Our ref: TR010022/S51 Response

1 July 2019

**A38 DERBY JUNCTIONS
PLANNING ACT 2008 SECTION 51: NOTIFYING PERSONS OF ACCEPTED
APPLICATION**

I am writing regarding the proposed A38 Derby Junctions scheme and your letters dated 21 May 2019 and 22 May 2019. Please see below the response of Highways England to the issues raised.

Drawing Number HE514503	Originator -ACM	Volume -DCO	Rev C02
Location A38_SW_PR_ZZ		I Type I Role I Number -DR-DC-9908

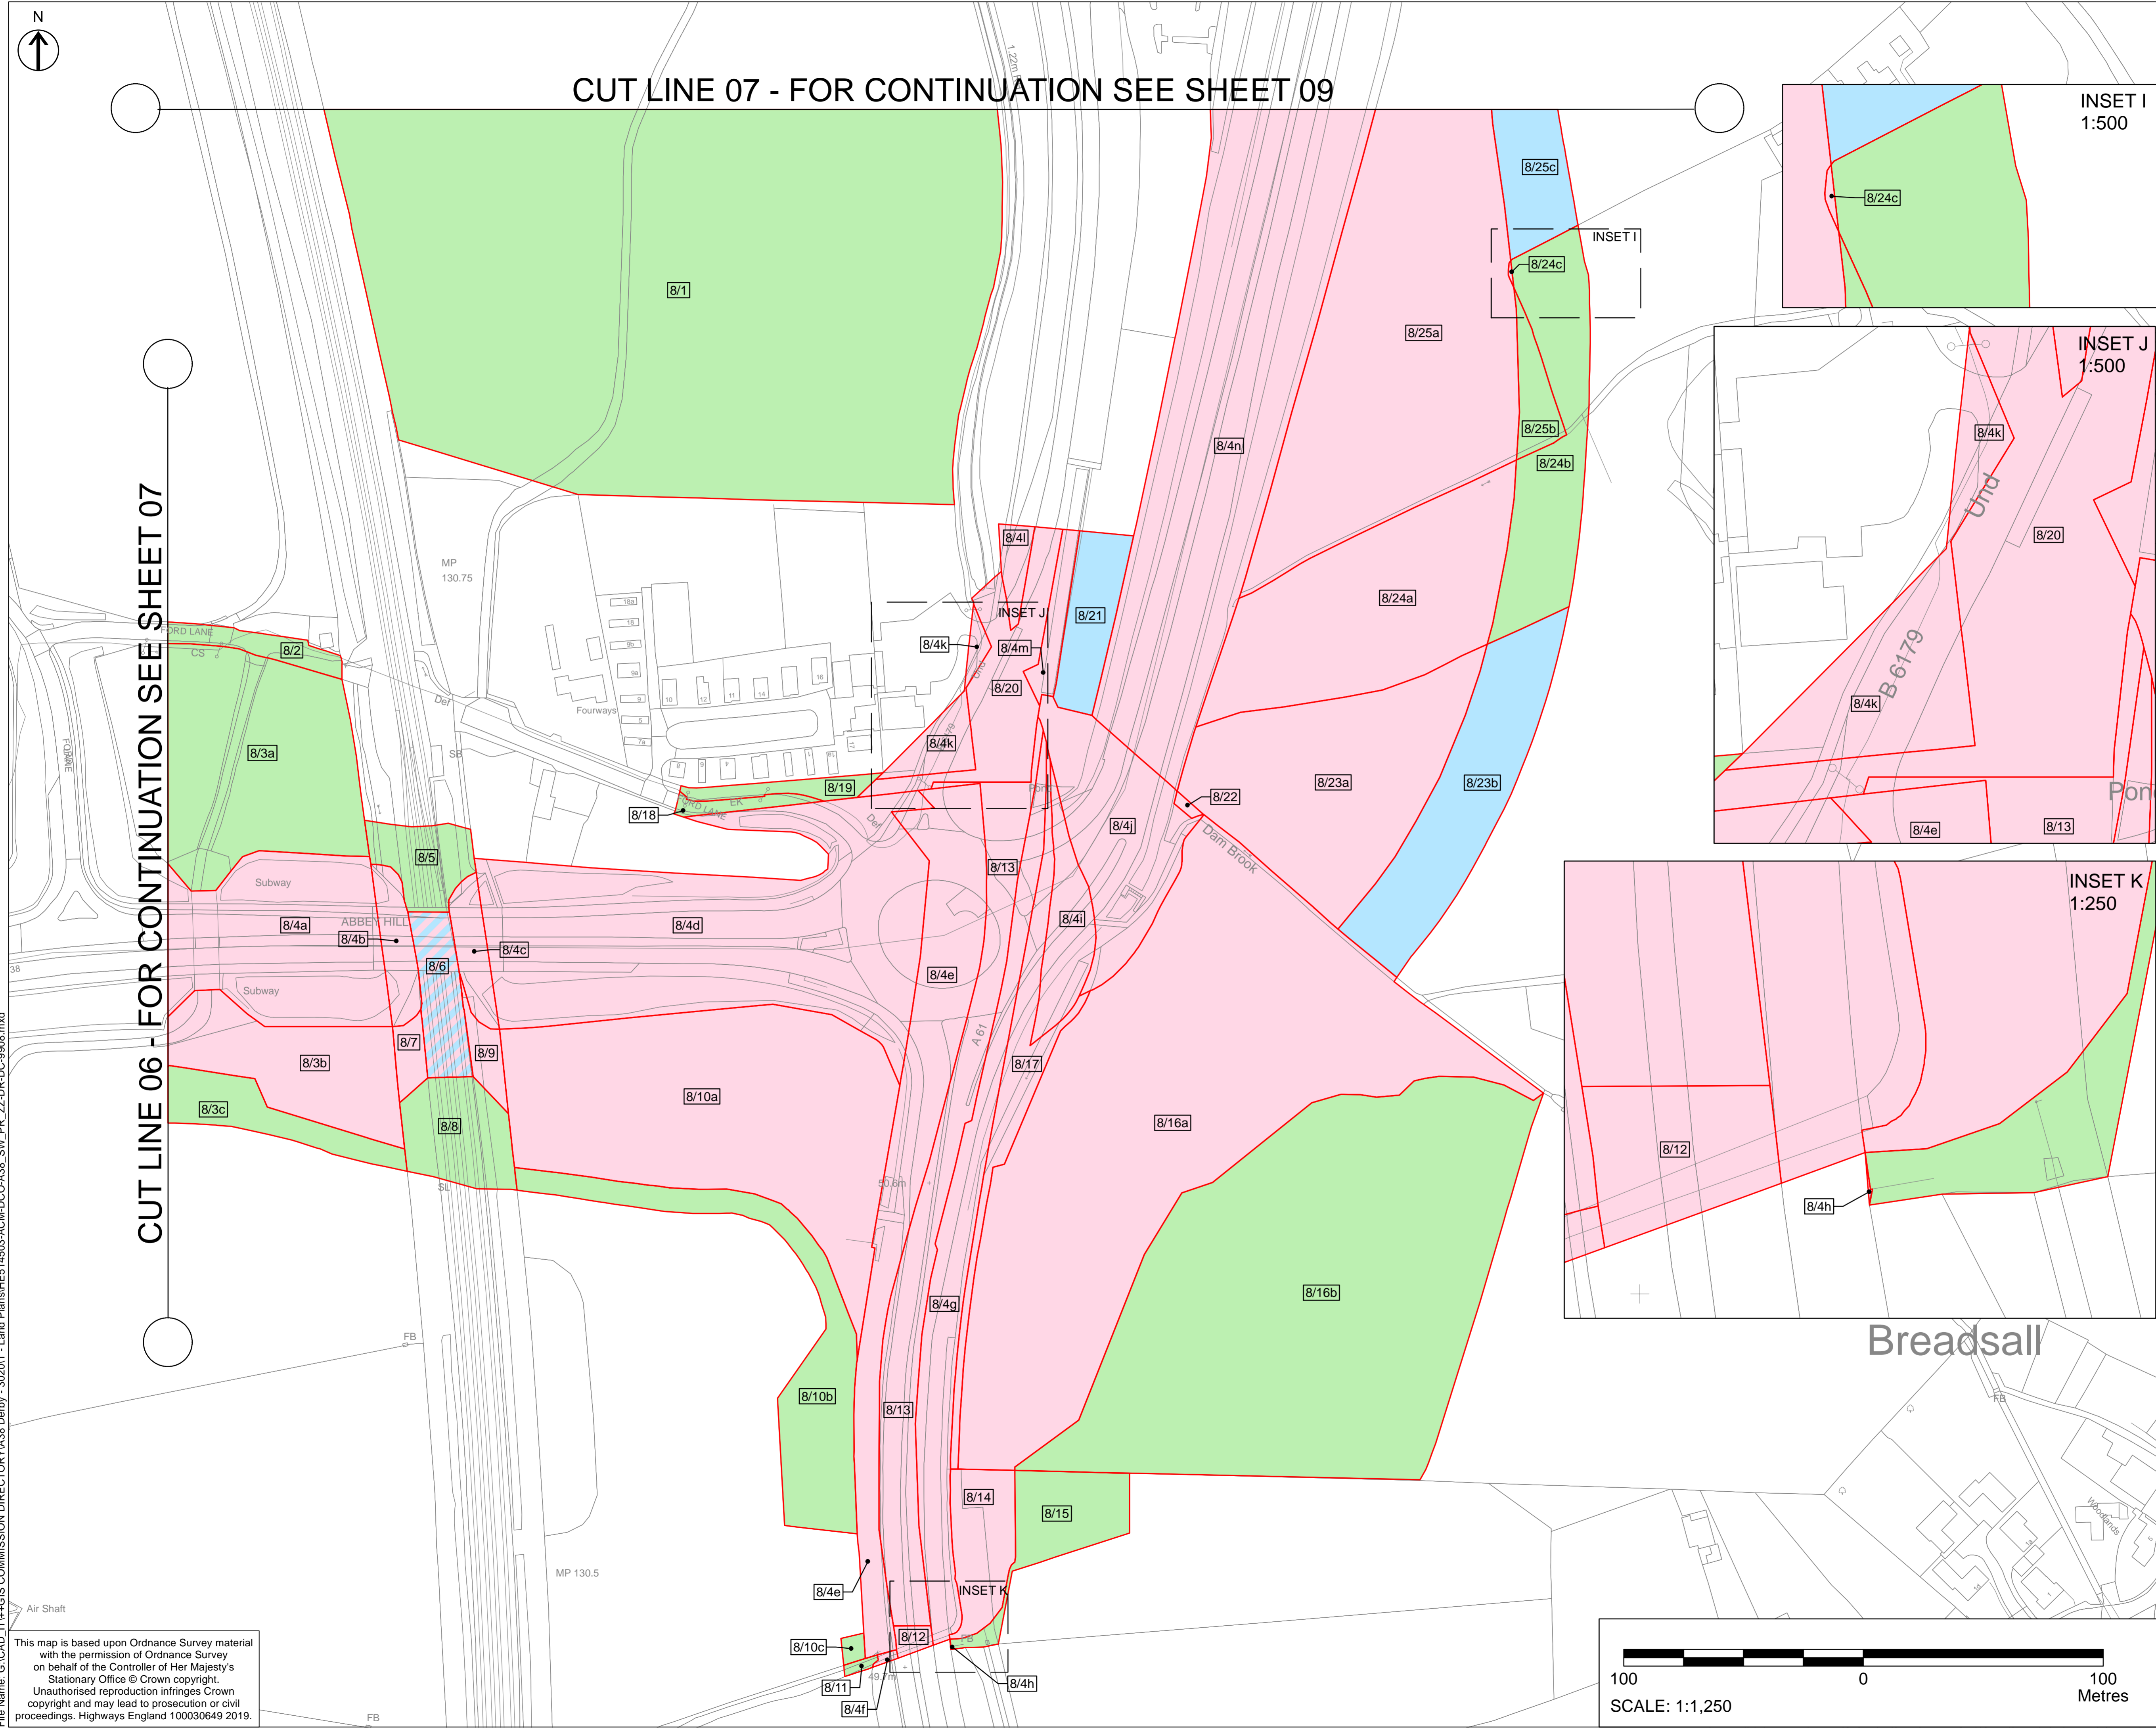
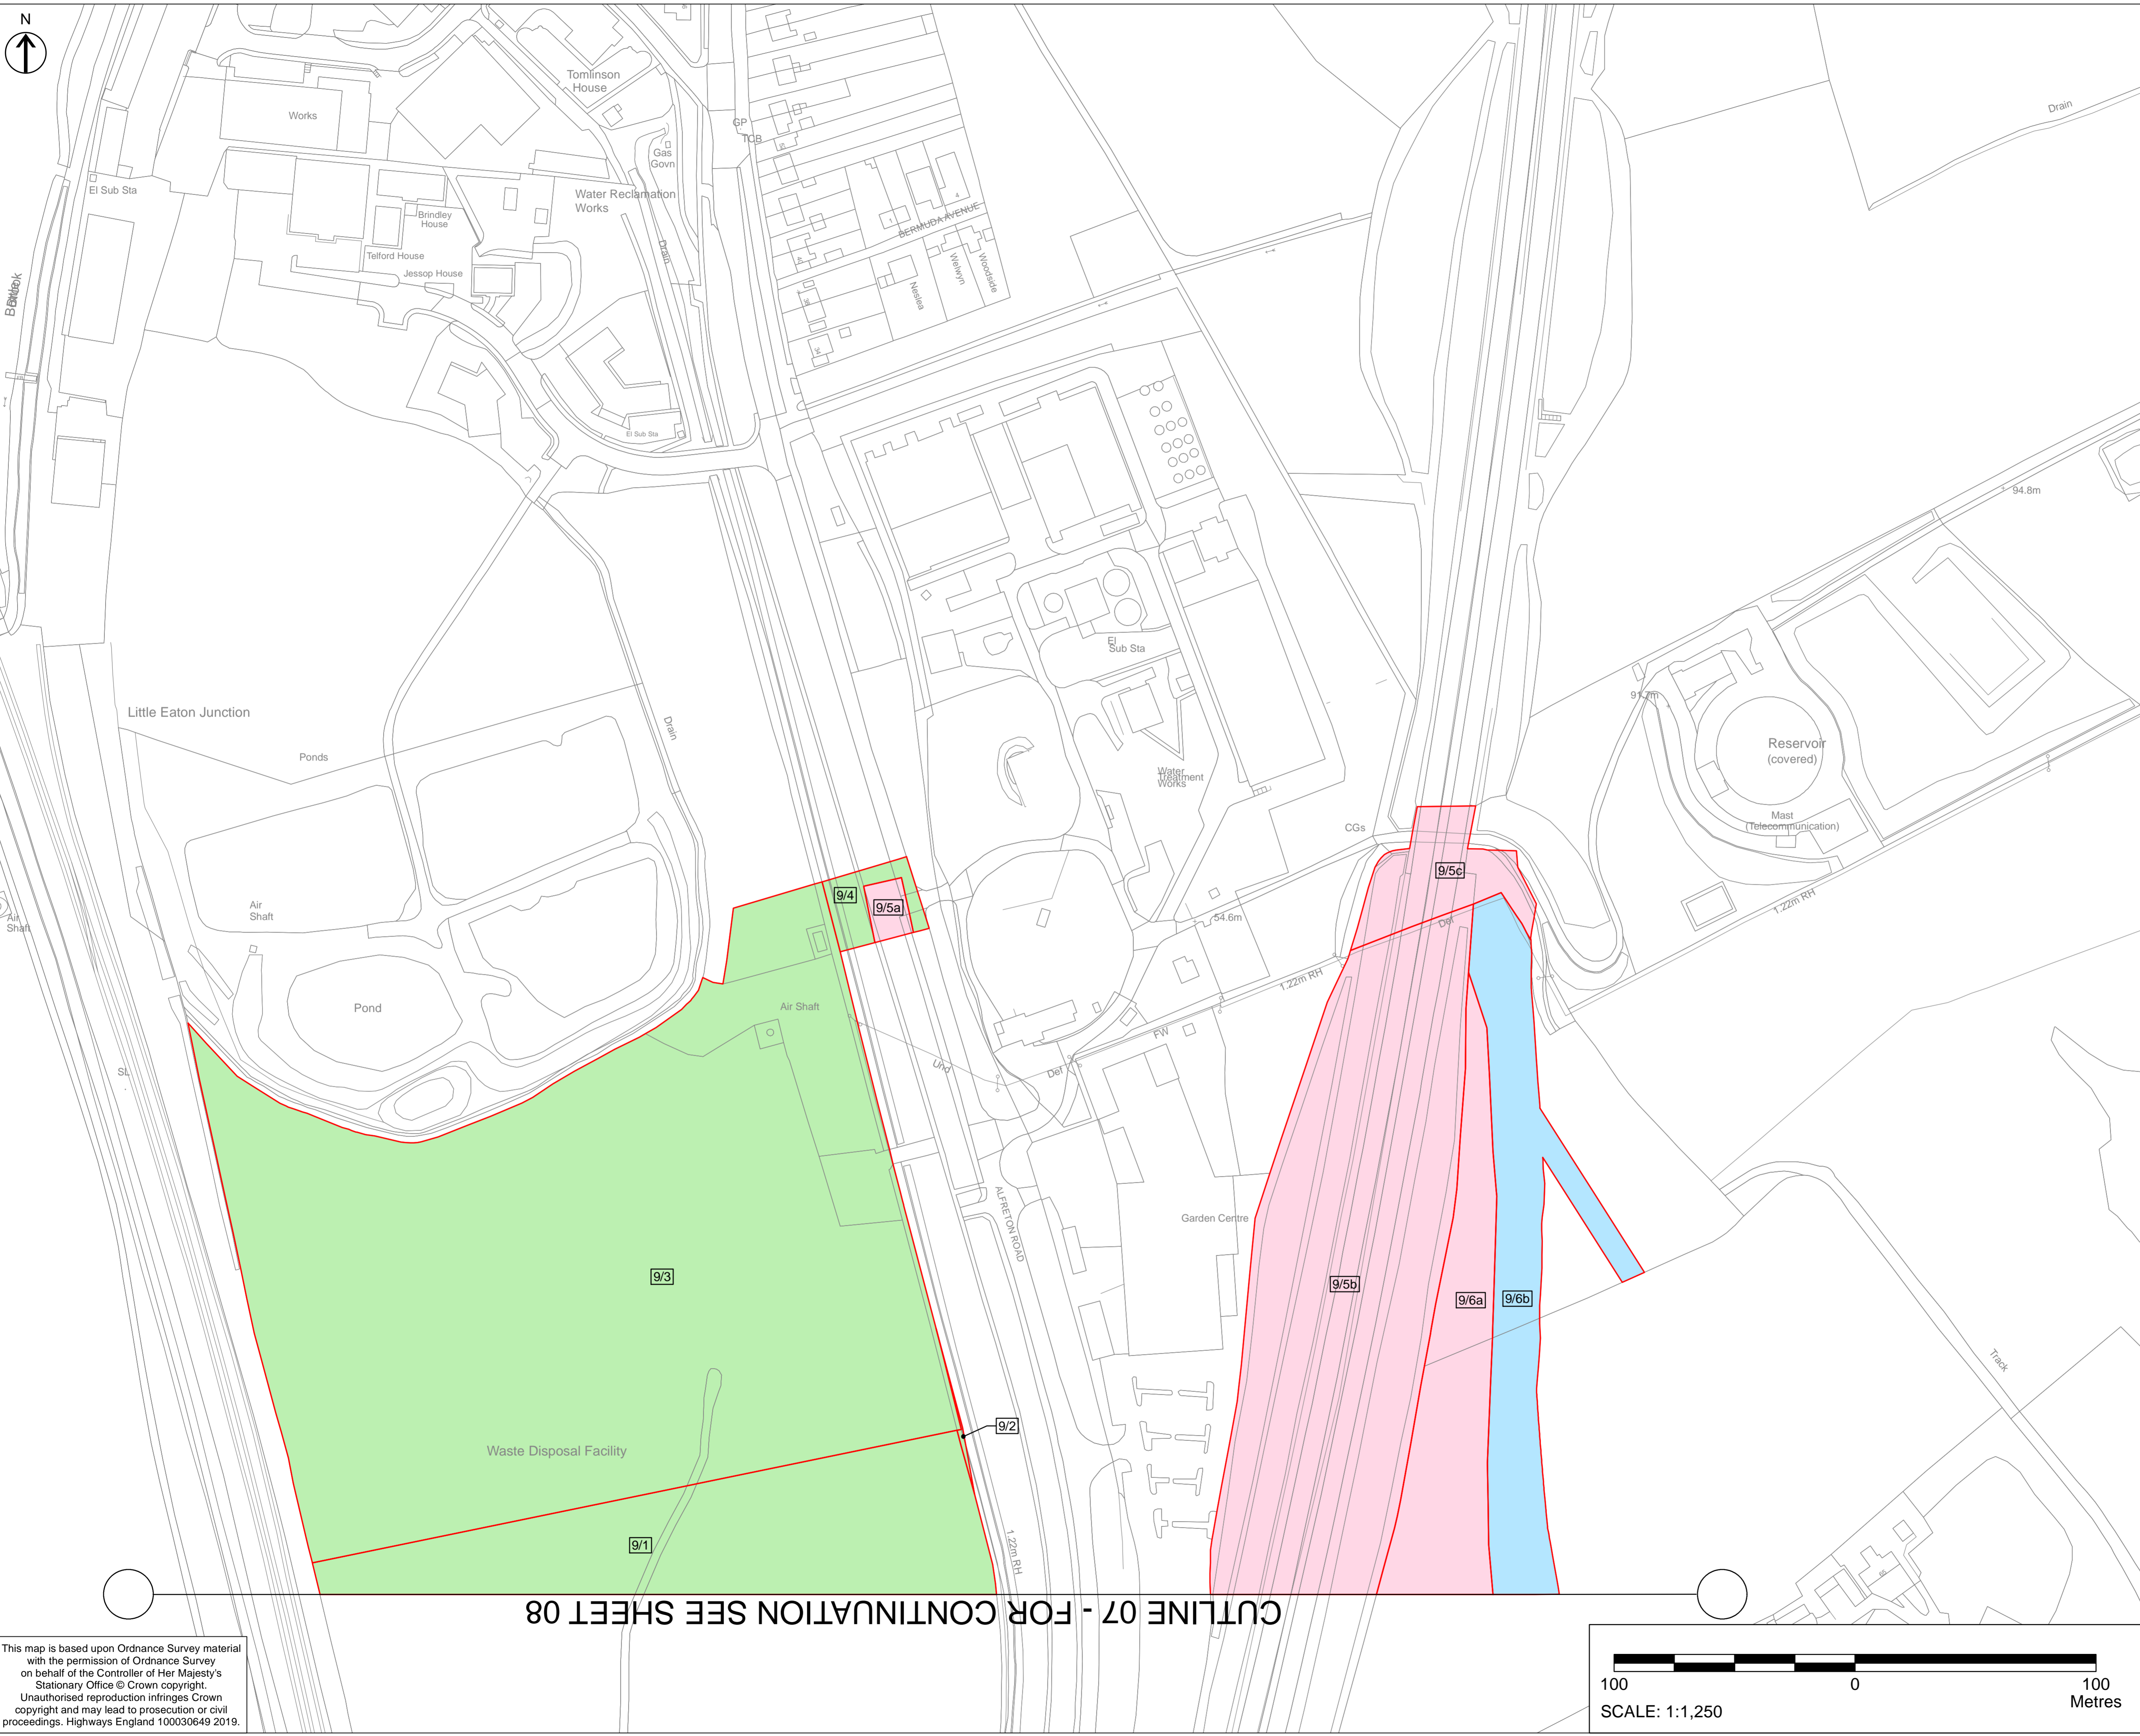
- Sheet 7 – Land outside DCO order limits highlighted yellow.
- Sheet 8 – 8/25c. Parcel is subject to cut-line. Amended and changed from green to blue. Reflected in BoR.

- Part 8 - 8/25c – changed from Temporary possession and use of land to Temporary possession and use of land and acquisition of rights over land. This change was to reflect the changes to the Land Plans as this plot is a subject to a cutline and needed to reflect the same as 9/6b. This parcel is affected by a utility diversion.

Accordingly, a revised set of Land Plans are provided (Sheets 1-11). These plans update the submission version and should be used in the examination of the application.
